**KIRKLEES METROPOLITAN COUNCIL
INVESTMENT & REGENERATION SERVICE**

DELEGATED DECISION TO DETERMINE PLANNING APPLICATIONS

Reference No: 2021/62/93523/W

Description: Erection of front dormer, alteration to front window and chalk white render to external side and rear walls and creation of raised platform to serve rear patio door.

dwg. no. 20/588/04b

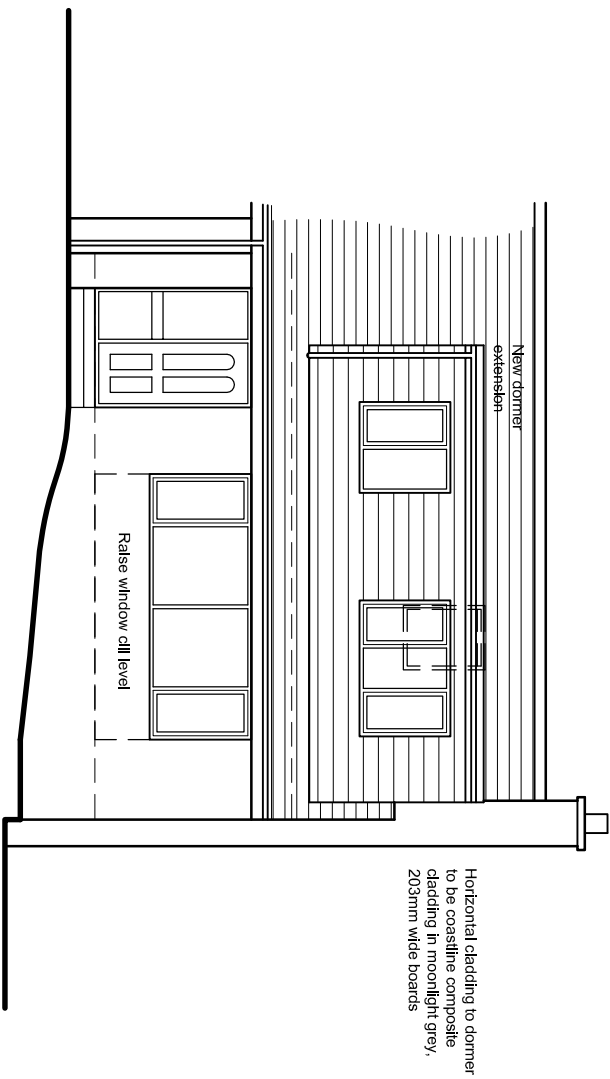
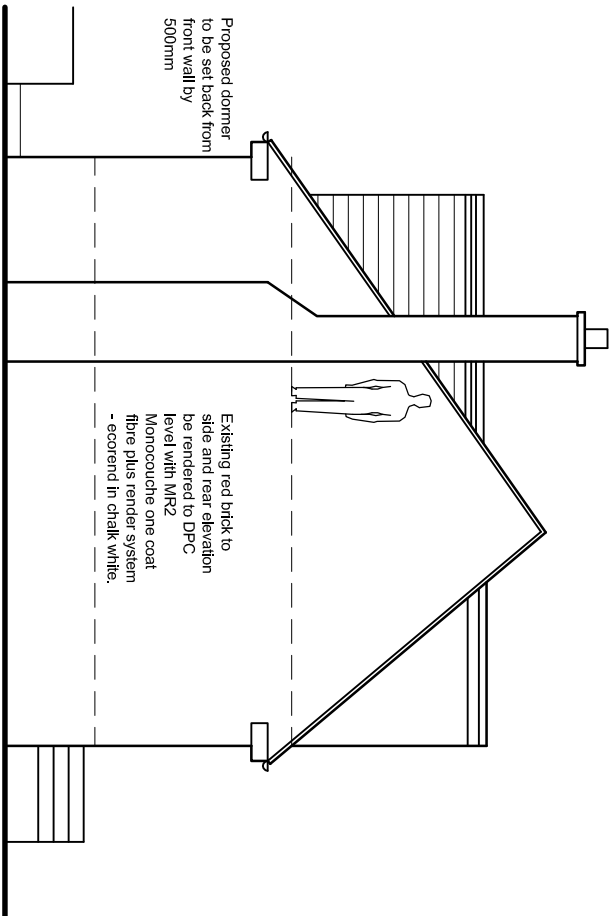
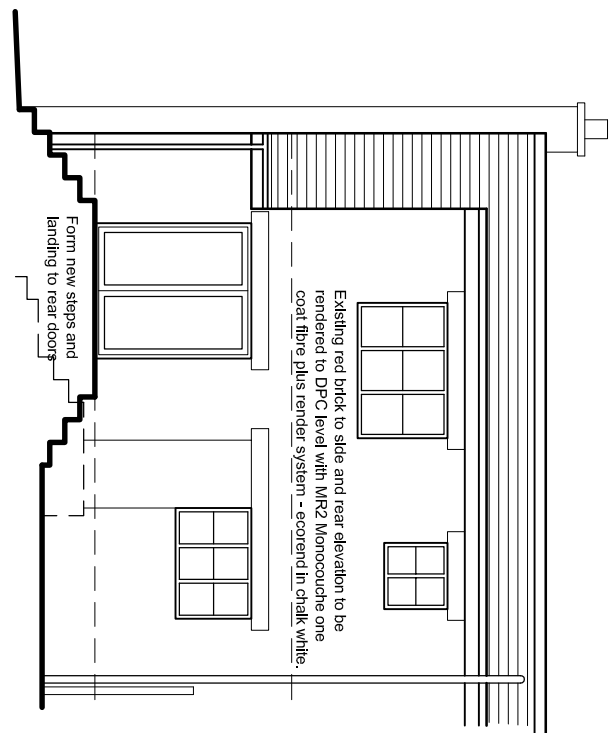
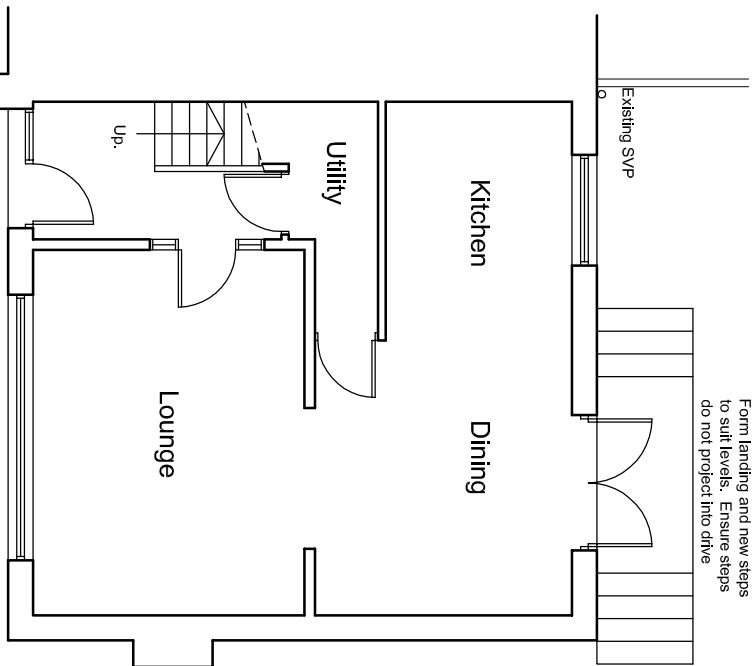
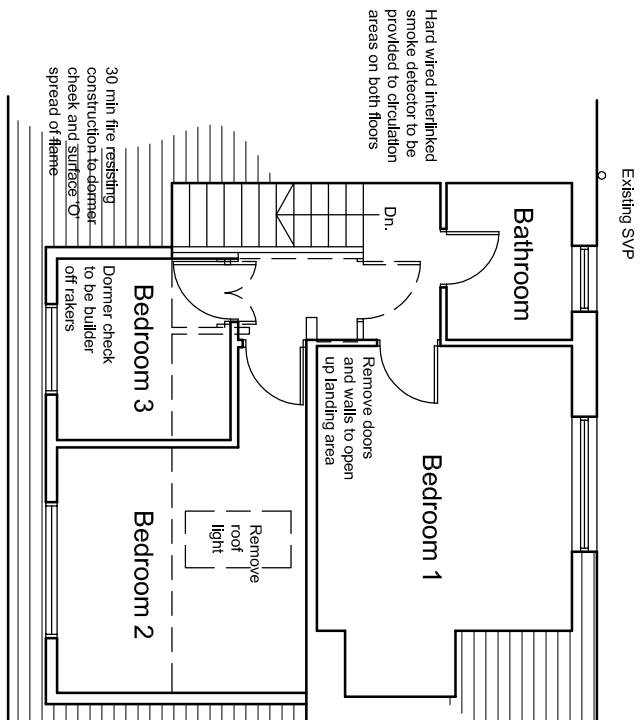
The case officer considered the application on review after assessing the streetscene and sought to have a greater set back from eaves to match the existing dormers within the streetscene. Following discussion with the agent regarding the need to cover up mismatching brickwork, it was assessed on site visit that the rear elevation would be mismatch and it was agreed to avoid white render to the primary elevation to reduce the visual impact of such a finish upon the streetscene while allowing the applicant to harmonise the rear finish of their brickwork satisfactorily.

The proposed dormer would be sizable however the streetscene is characterised by many front dormers of unsympathetic design, i.e. large, mismatching colours to the roof and various roof designs. This is taken into account light of paragraph 5.26 which refers to modern flat roof dormers and whether they are a characteristic of the street scene.

The dormer is set back to a similar as existing front dormers to neighbouring properties, it is also set down from the roof ridge and with its similarly coloured cladding materials to the roof would have a reduced impact upon the street scene than that of the existing structures to neighbouring properties.

The raising of the window cill to the front would be considered a small alteration and providing the brickwork infill and fenestration detail is to match, this element of the proposal would be small scale and acceptable without detrimental impact on visual amenity. Examples on the street scene show this to be in keeping with the streetscene.

The use of render is resisted on dwellinghouses in particular where there are no examples on the streetscene and on semi detached properties. Initially all of the dwelling was proposed to be rendered and the proposal has been amended such that render is solely to the side elevation and the rear elevation and is intended to cover mismatched brickwork to the rear. The host dwelling maintains its original materials of construction to the primary elevation. The use of render to the rear and side is therefore concluded to be acceptable in this case.

3. The external brick used in the construction of the alteration to front window hereby approved shall in all respects match those used in the construction of the existing building. The materials used in the construction of the alteration to front window shall be retained thereafter.

4. The external materials of construction used in the construction of the dormer to front hereby approved shall be of a dark grey colour finish. The colour finish shall be retained thereafter.
